From: Ian Oldfield [REDACTED]
Sent: 12 September 2021 17:29
To: Planning <Planning@arun.gov.uk>
Cc: [REDACTED]
Subject: Correction to drawing: AW/276/21/HH

Re: Planning application – AW/276/21/HH

PROPOSED WORKS	DRAWING	LOCATION
Attached Annexe/Conservatory Conservatory to Garden Room	1. Ground Floor Plan – Existing & Proposed Scale 1:100 @ A3 – Revised 20210912	The Quest, Cypress Way, Bognor Regis, West Sussex, PO21 4DF

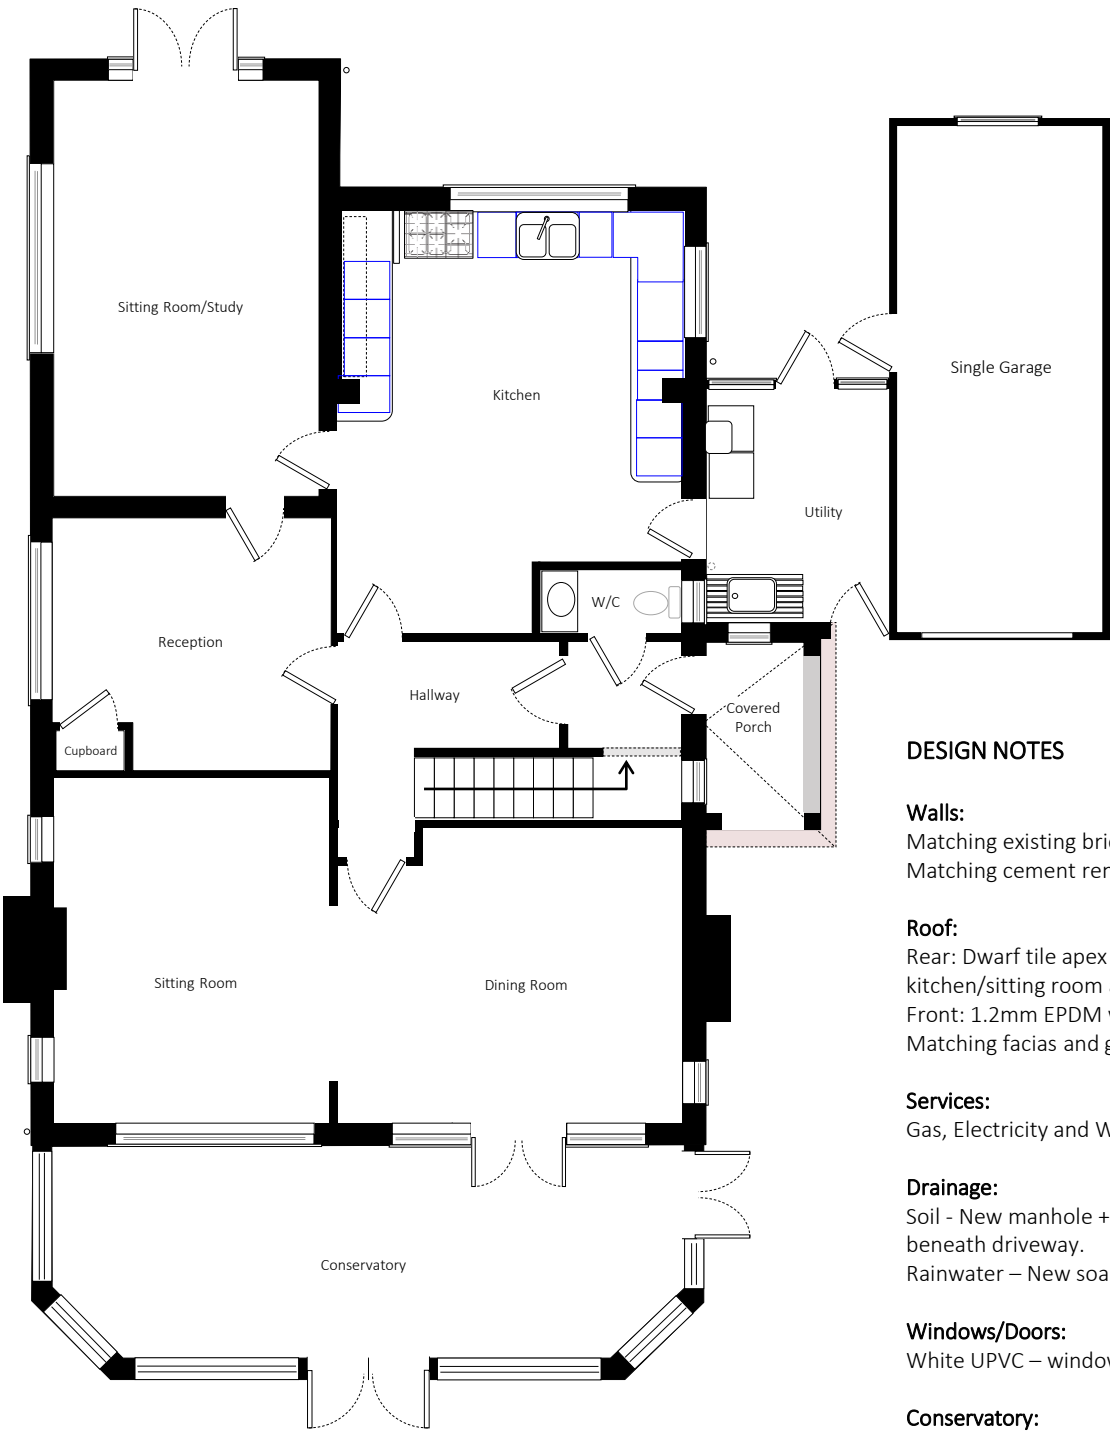
I have noticed a minor drawing error on the Ground Floor Plan and the West Elevation in respect of the Annexe outside door. I have corrected this and attach hereto the full set of drawings with no.s 1 & 5 indicating a revision. As will be seen on the Ground Floor Plan, the door was placed slightly hidden and about 0.5m from the correct location. I believe you will agree this makes no material change to the proposed development.
